Application No: BR/20/26/PL

Recommendation Report for Planning Permission

LOCATION: 51a Aldwick Road
Bognor Regis
PO21 2NJ

PROPOSAL: Retention of change of use of first and second floor office to a 5 bed HMO. This application is in CIL Zone 4 (Zero Rated) as other development.

PROPOSED FIRST FLOOR PLAN

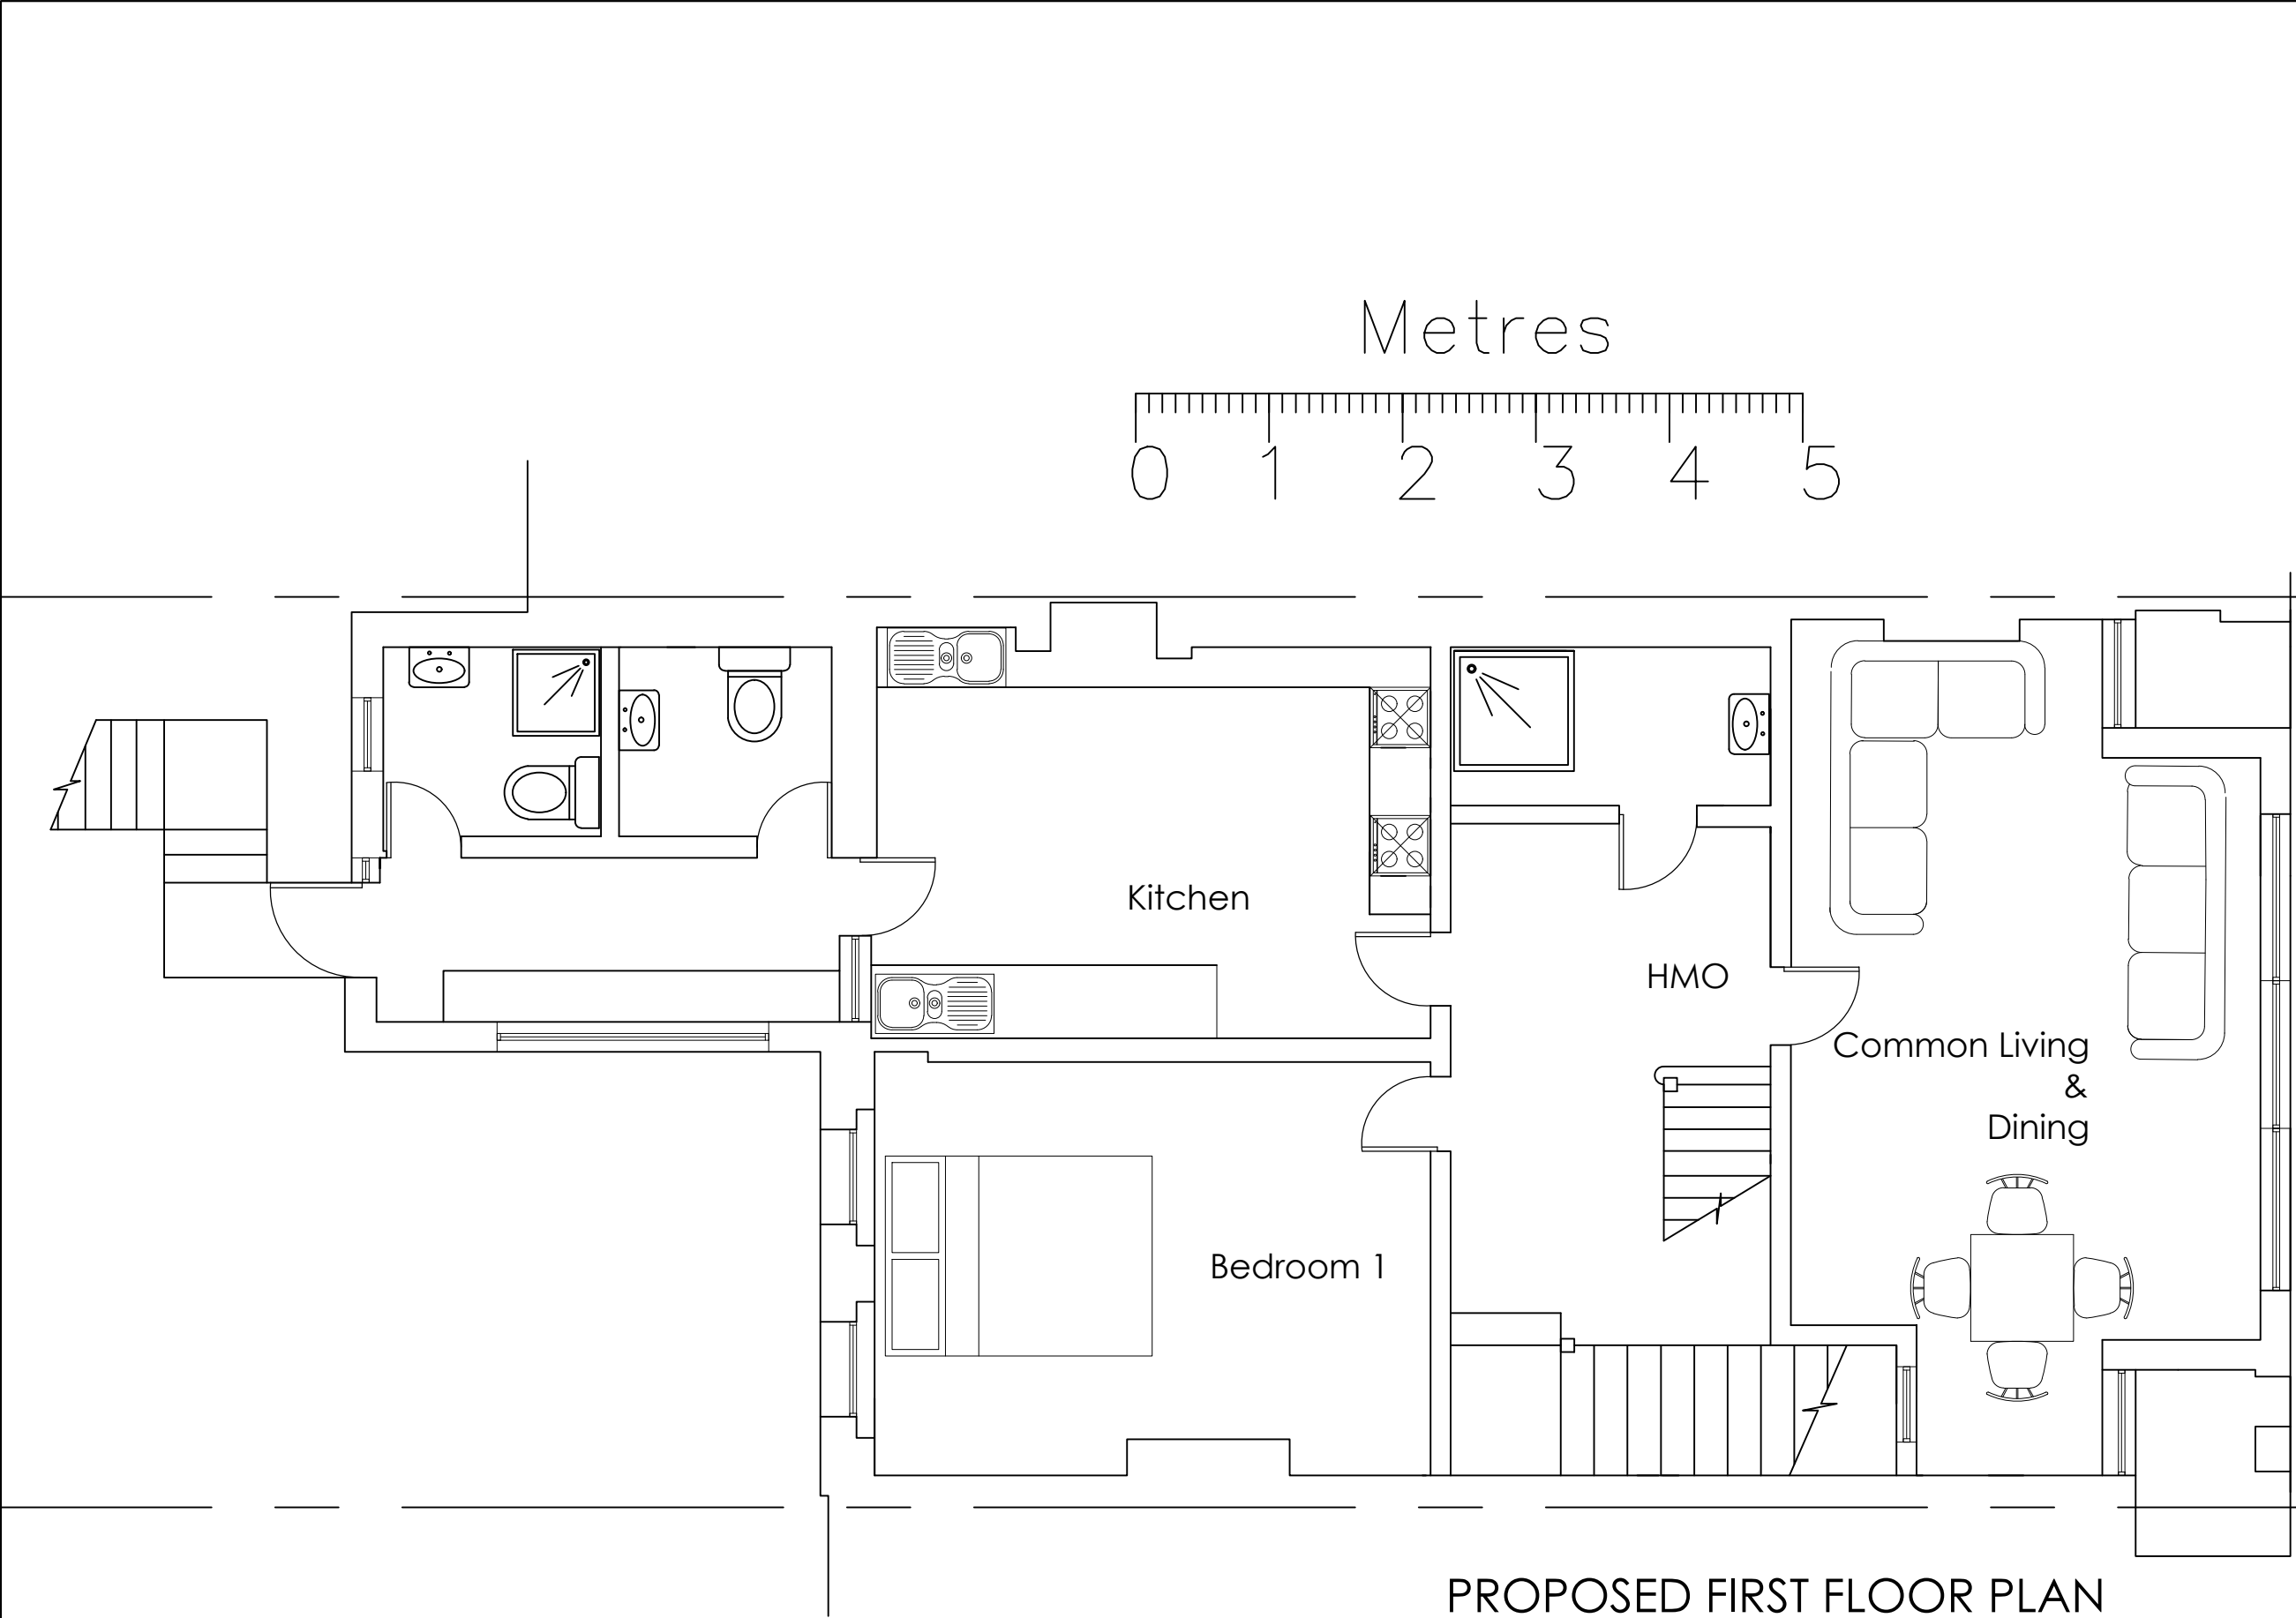
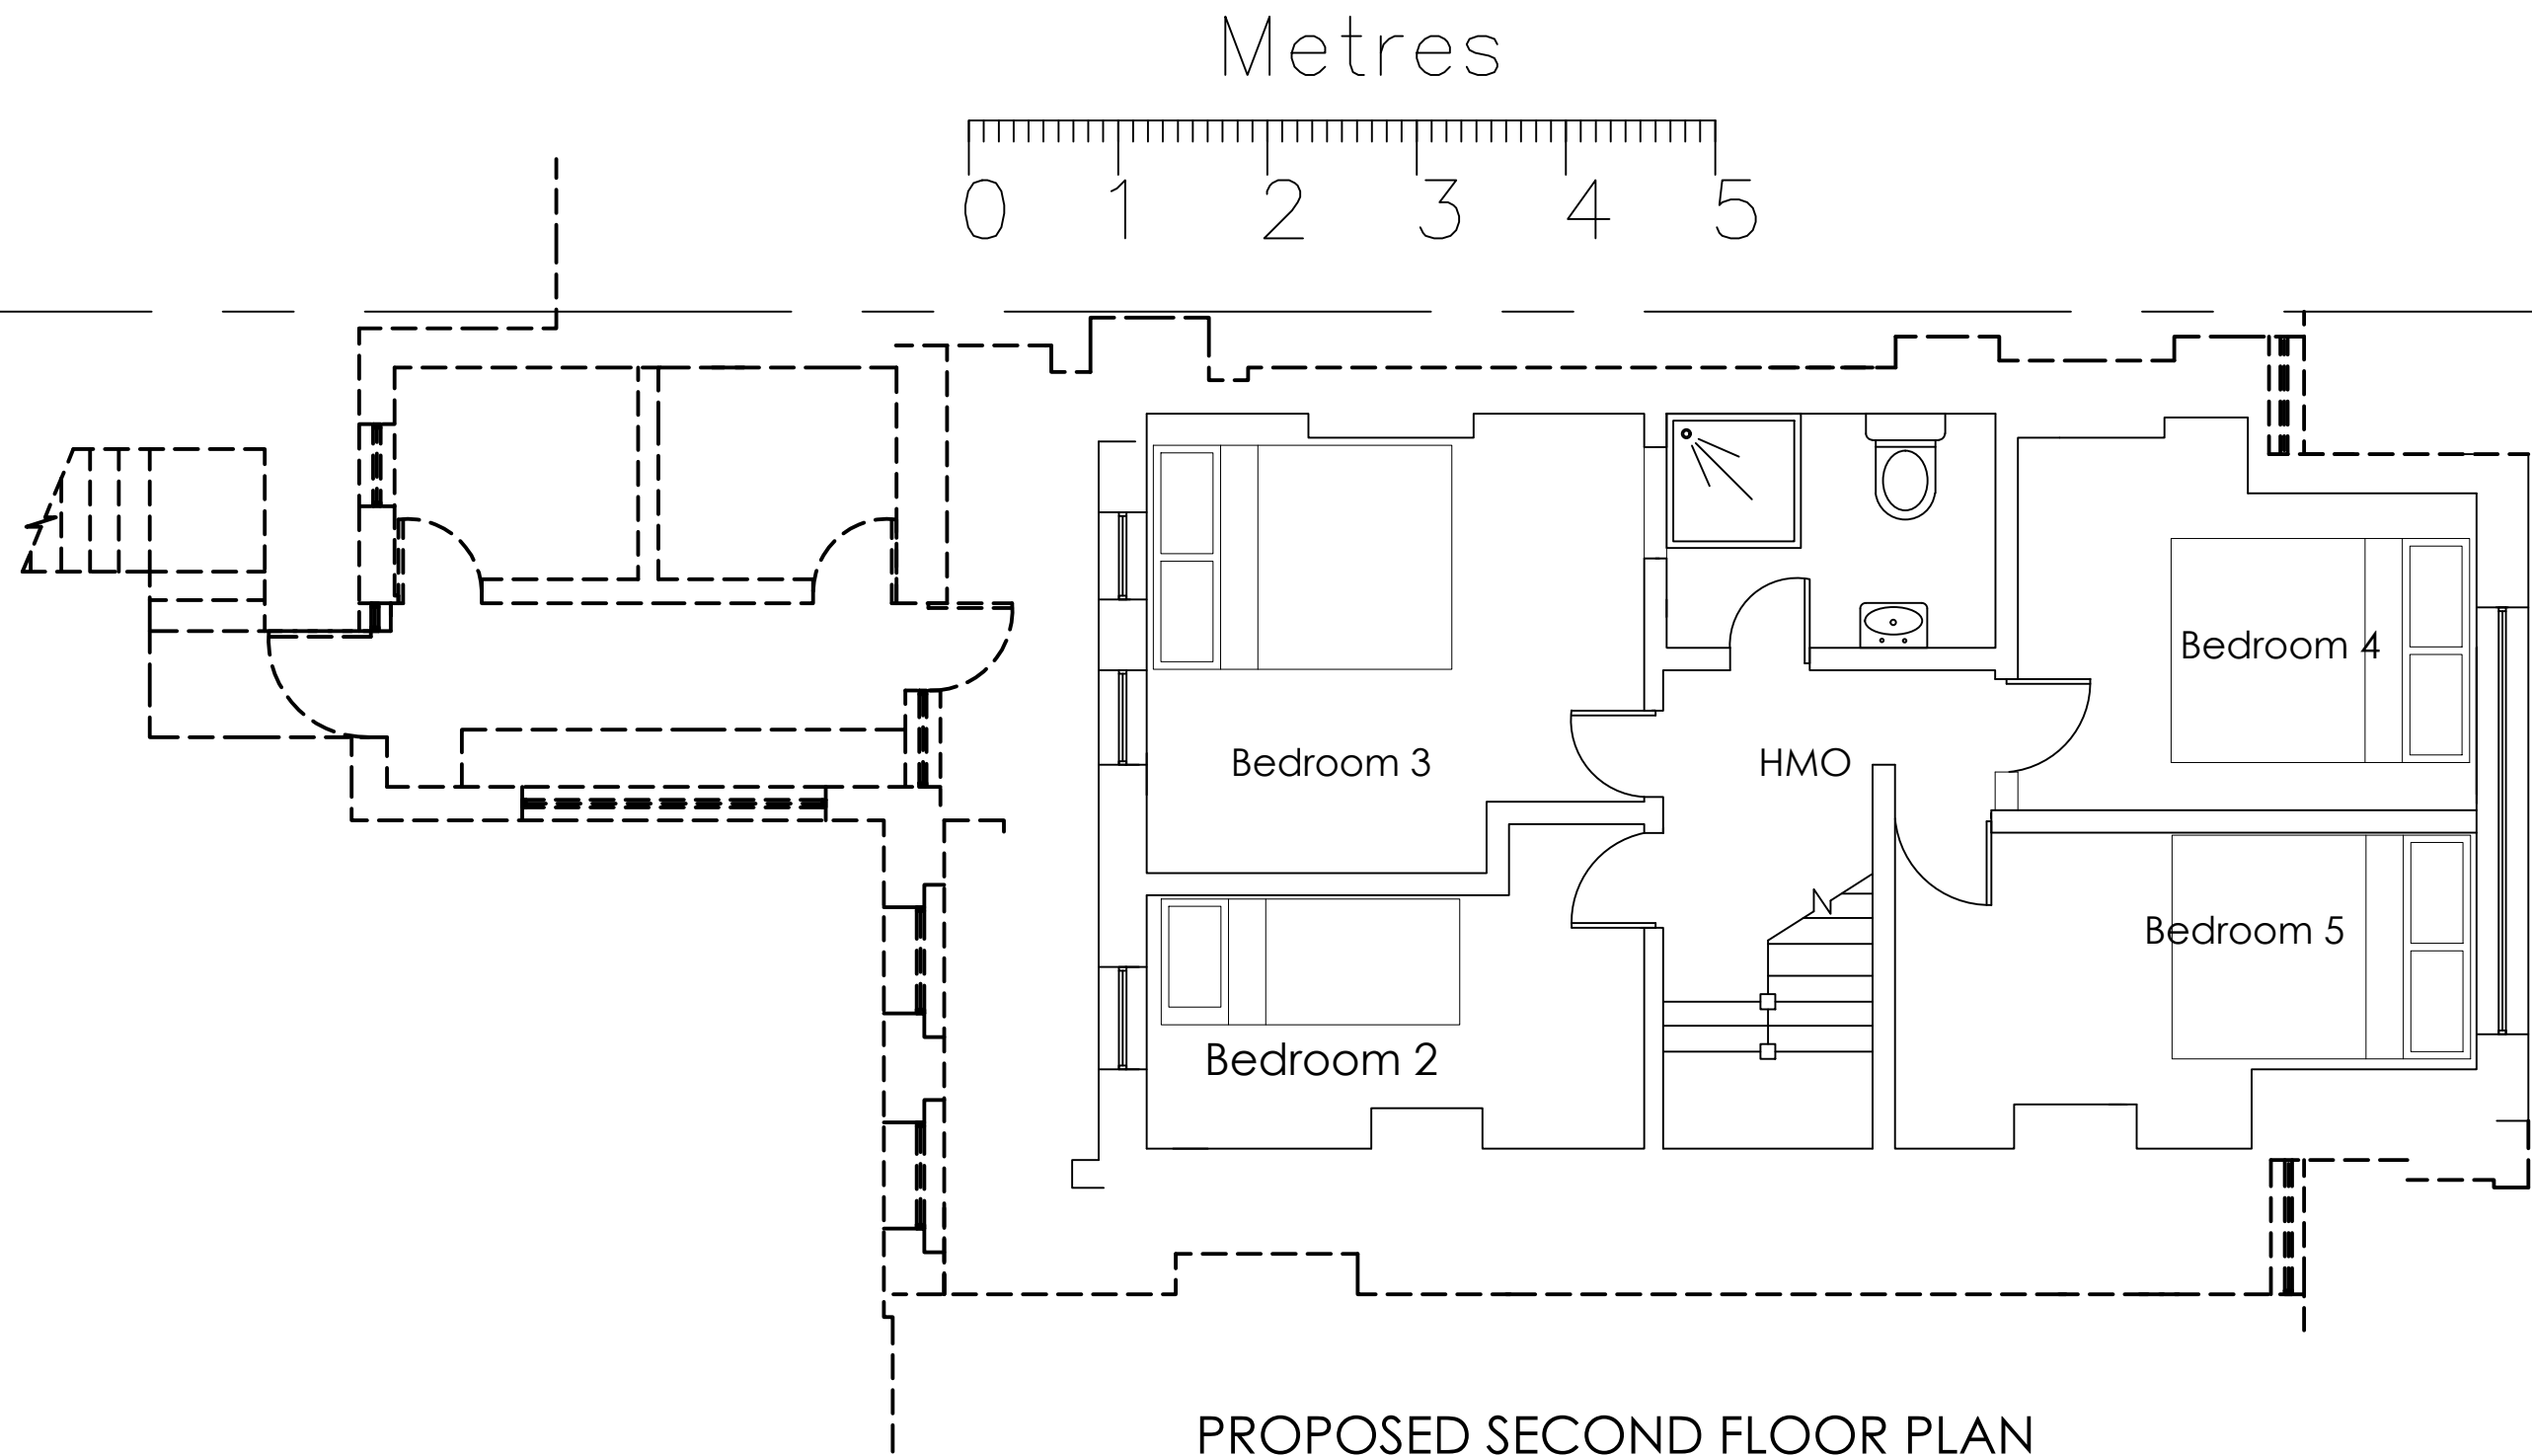
For a new dwelling, the NDSS requires bedrooms for a single occupant to have an area of at least 7.5sqm and be at least 2.15m wide. Whilst some of the bedrooms are shown with double beds on the proposed plans, all bedrooms would be for a single occupant, and so the bedrooms have been assessed

against the standard for a single bedroom. Bedrooms 1 and 3 meet this standard, and bedrooms 4 and 5 fall slightly short at 7.1sqm. Bedroom 2 has an area of 5.9sqm, which is less than the recommended standards. As the NDSS are not directly applicable to HMO bedrooms, and the sizes of bedrooms in HMOS are controlled through the HMO licensing process, this is considered acceptable for the purposes of planning in this instance. A licence would be required for this HMO. The Private Sector Housing Team have commented in respect of various matters, including the size of bedrooms and communal areas. The applicant is encouraged to review these comments in full.

All bedrooms are served by a window and have adequate access to natural light.
